DOC17/599447-01
SSD 8647

SSD 8647 – HORNSBY HOSPITAL RE-DEVELOPMENT – ENVIRONMENTAL IMPACT STATEMENT (EIS)

HORNSBY HOSPITAL RE-DEVELOPMENT STAGE 2 EIS

Noise Monitor Along Derby Street: Tuesday 30 May, 2017

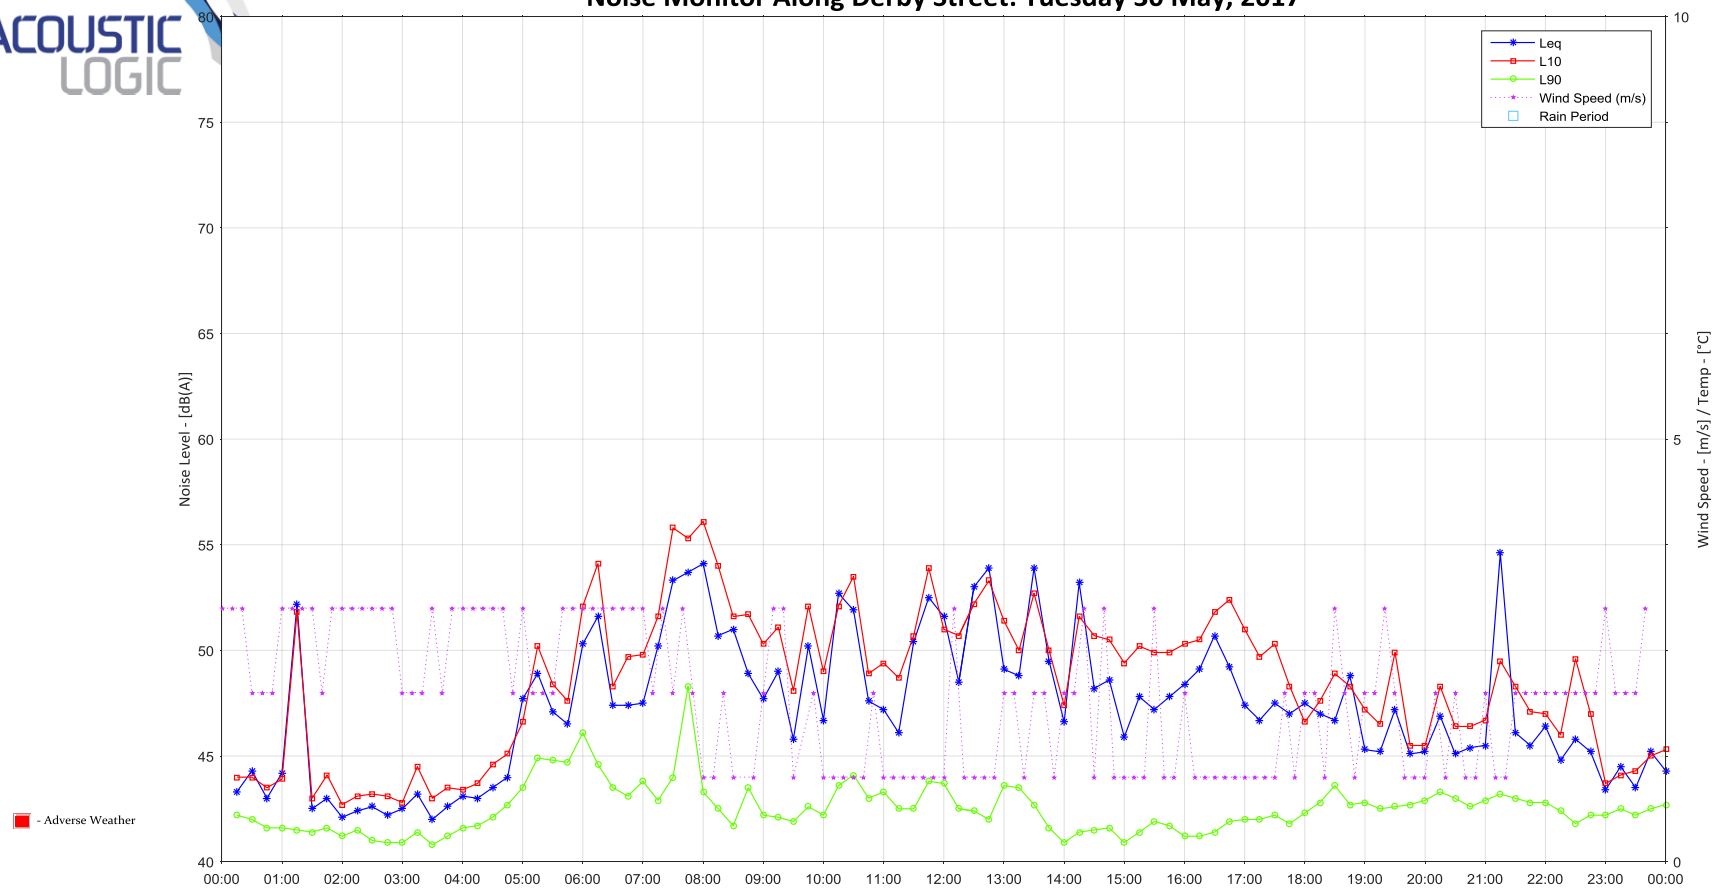
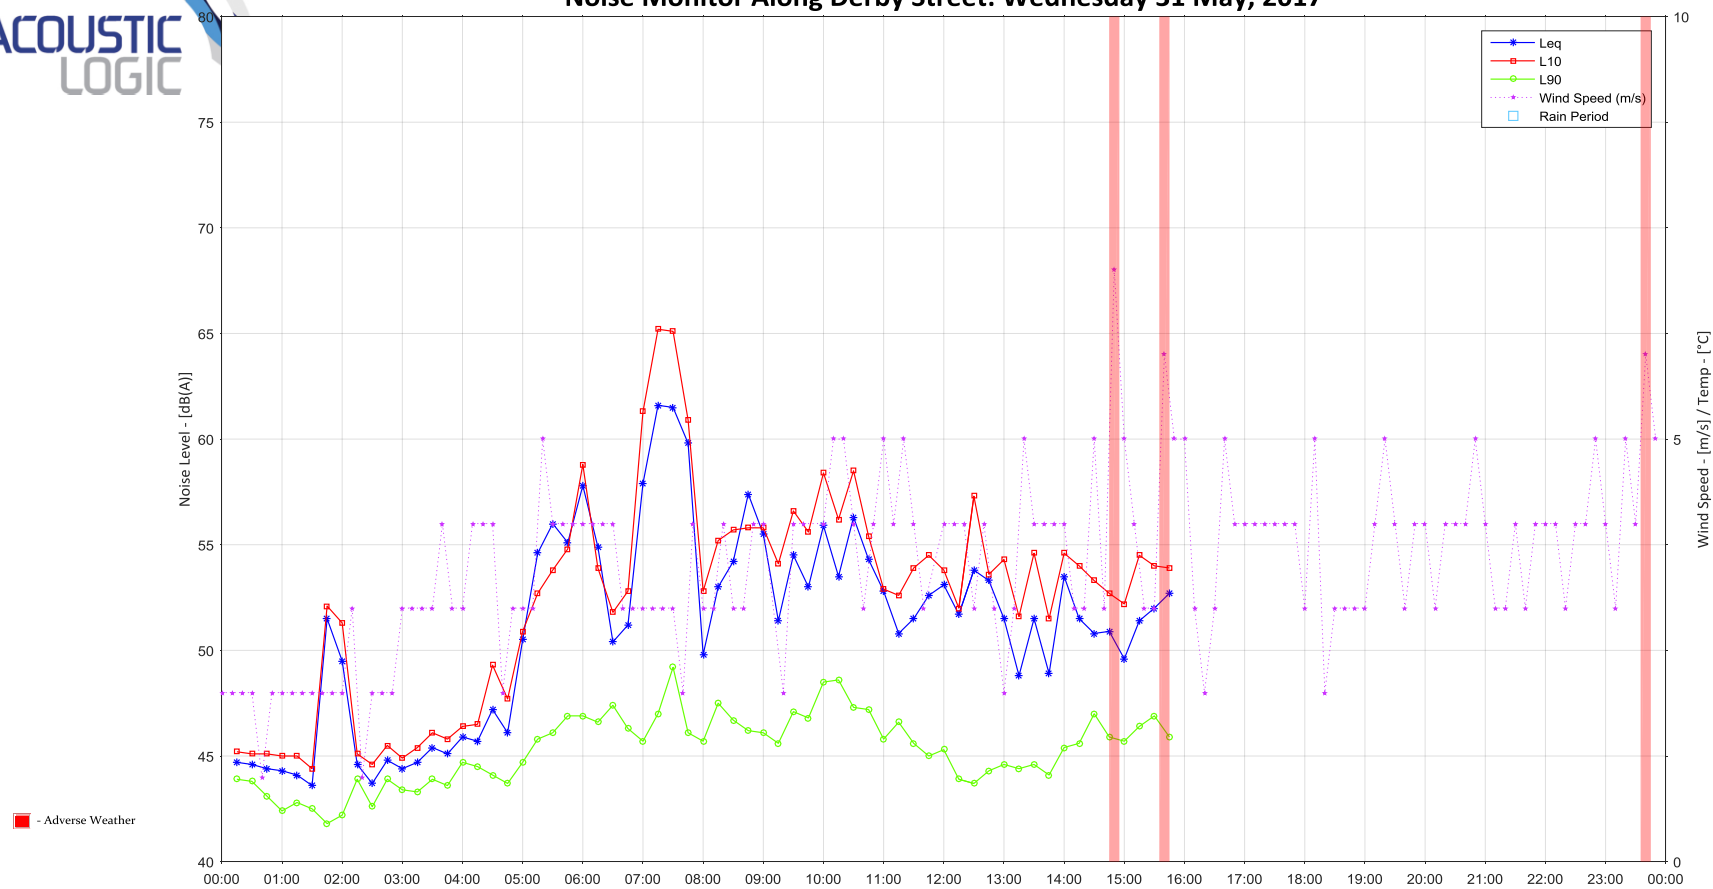
The EPA is concerned that the noise monitoring graphs presented in 'Appendix 2 - Noise Monitoring Along **Derby Street**' to EIS Appendix Q appear instead to be a duplicate of graphs for Burnett Street and thus that the data for Derby Street appears to have been omitted from the EIS.

- (a) the equivalent of a week's worth of valid data, measured at the potentially most affected noise sensitive receiver locations in Burdett Street, Derby Street and Palmertson Road; and
- (b) the results of attended monitoring, graphical results of unattended monitoring with a complete and accurate legend together with a table of assessment background and daily ambient levels.
